45-53 Macleay Street Potts Point

Response to Submissions

This Submissions Report has been prepared by Urbis on behalf of Time & Place Pty Ltd (**the Applicant**) to address the matters raised during the public exhibition of the State Significant Development Application (**SSDA**) for the redevelopment of 45-53 Macleay Street, Potts Point (SSD-79316759).

2 ENVELOPE - ELEVATION_NORTH
1 : 200

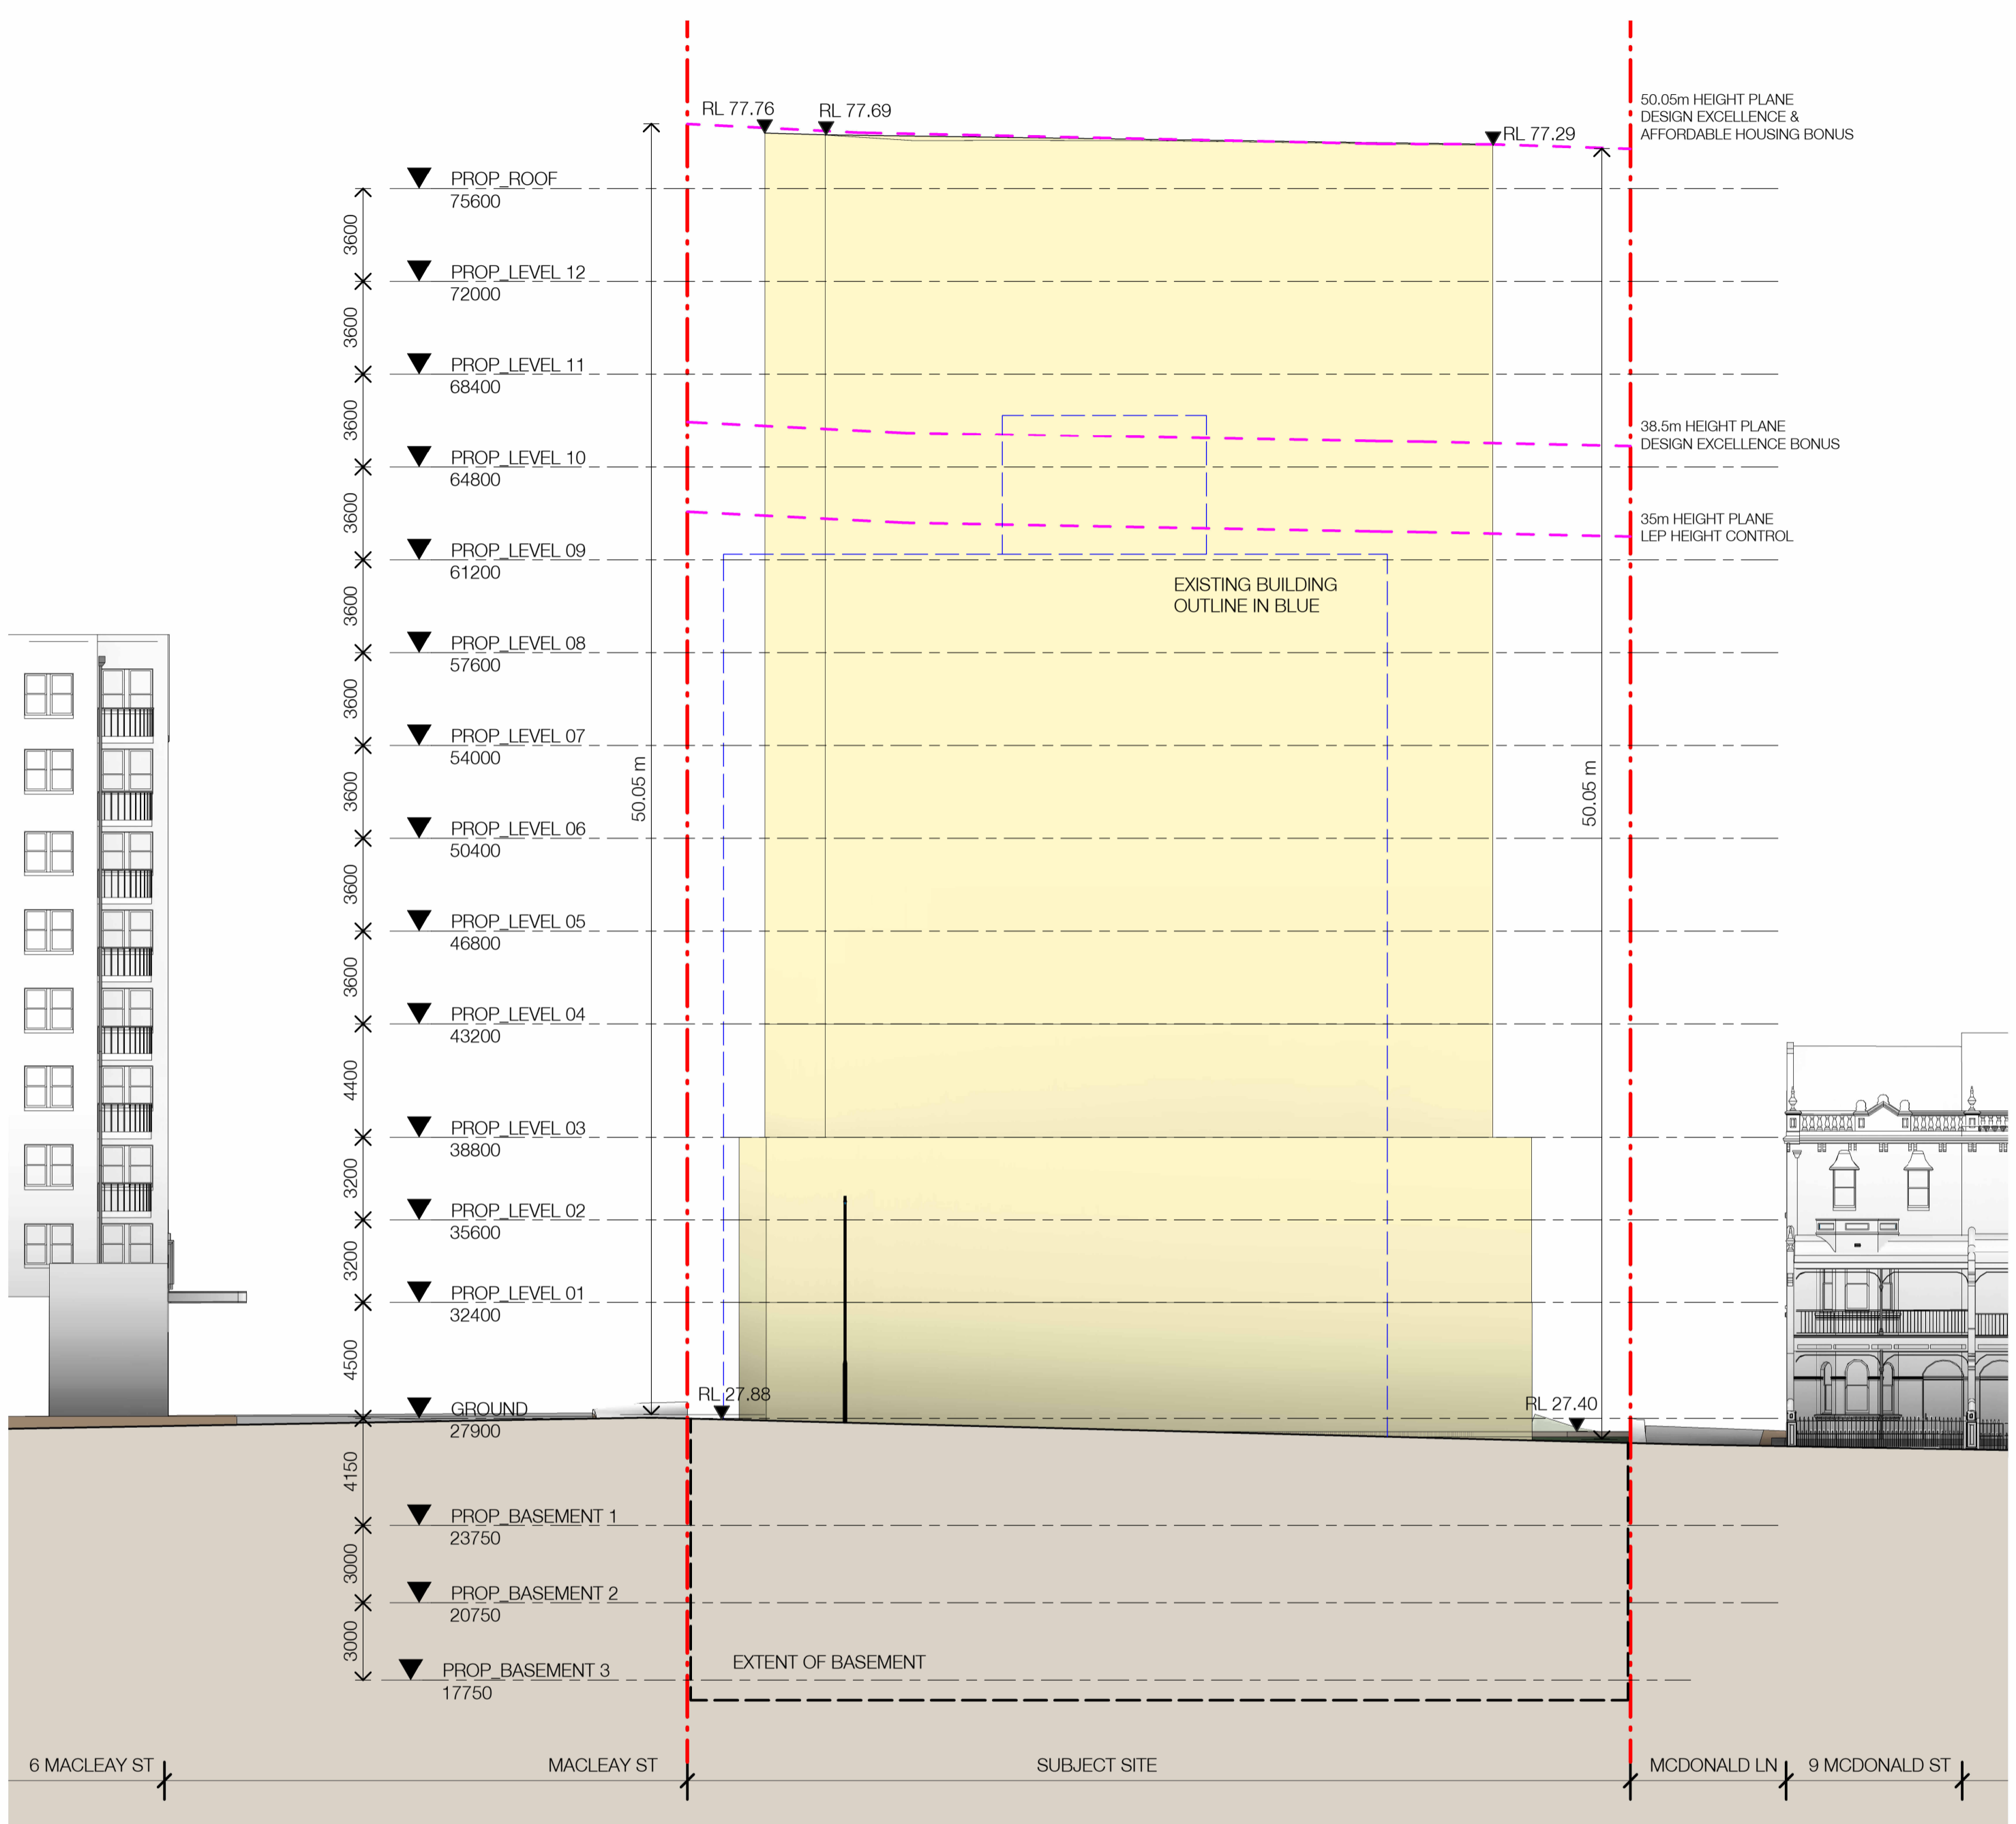
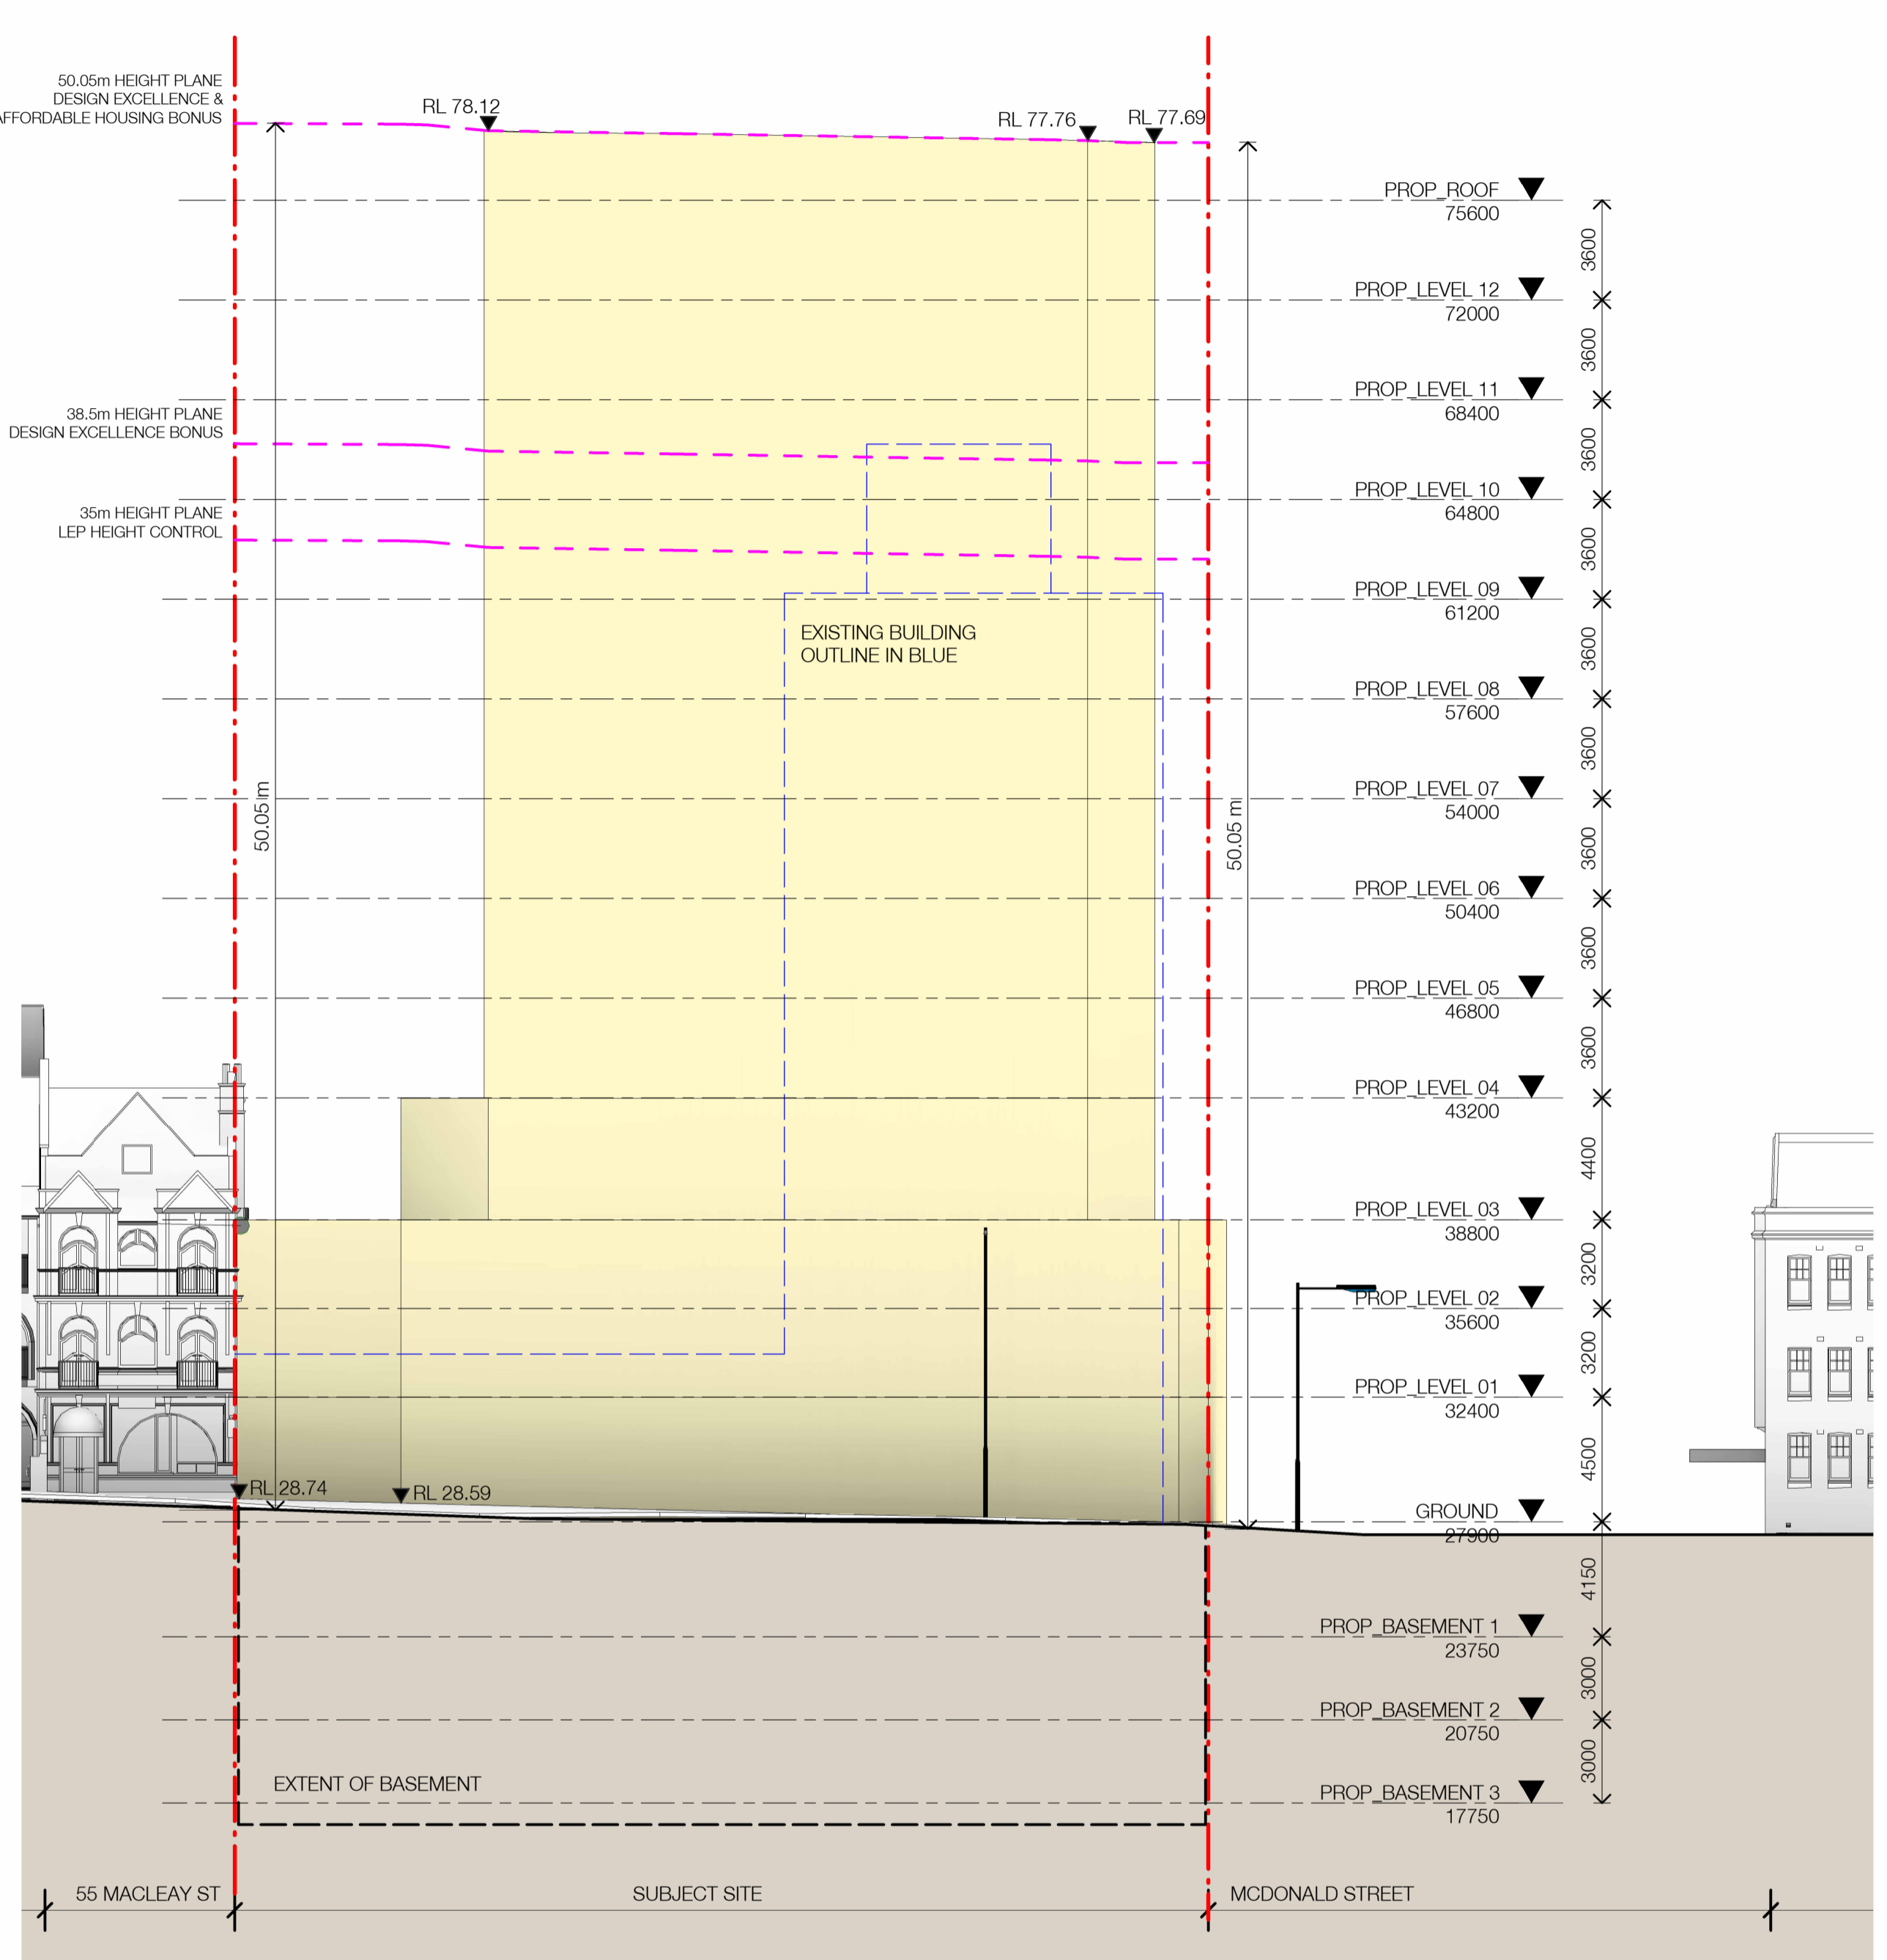
Issue Raised	Response	RTS Reference
Department of Planning, Housing and Infrastructure		
Building height		
<ul style="list-style-type: none"> ▪ Confirm that the building envelope height fully complies with the maximum building height permitted under State Significant Planning Policy (Housing) 2021 (Housing SEPP) by providing: <ul style="list-style-type: none"> – an overlay of the building envelope plan over the survey plan, with existing ground levels, contours and the uppermost points of the building envelope clearly notated – updated elevation plans dimensioning the uppermost points of the building envelope with the existing ground level directly underneath – an updated building height plane diagram which depicts the maximum height RIs for the site, and the maximum building envelope RIs, as the northern elevation appears to depict a building height breach. 	<p>Additional plans have been provided by SJB to confirm that the proposal fully complies with the maximum building height permitted under the Housing SEPP.</p>	<p>Appendix C</p>
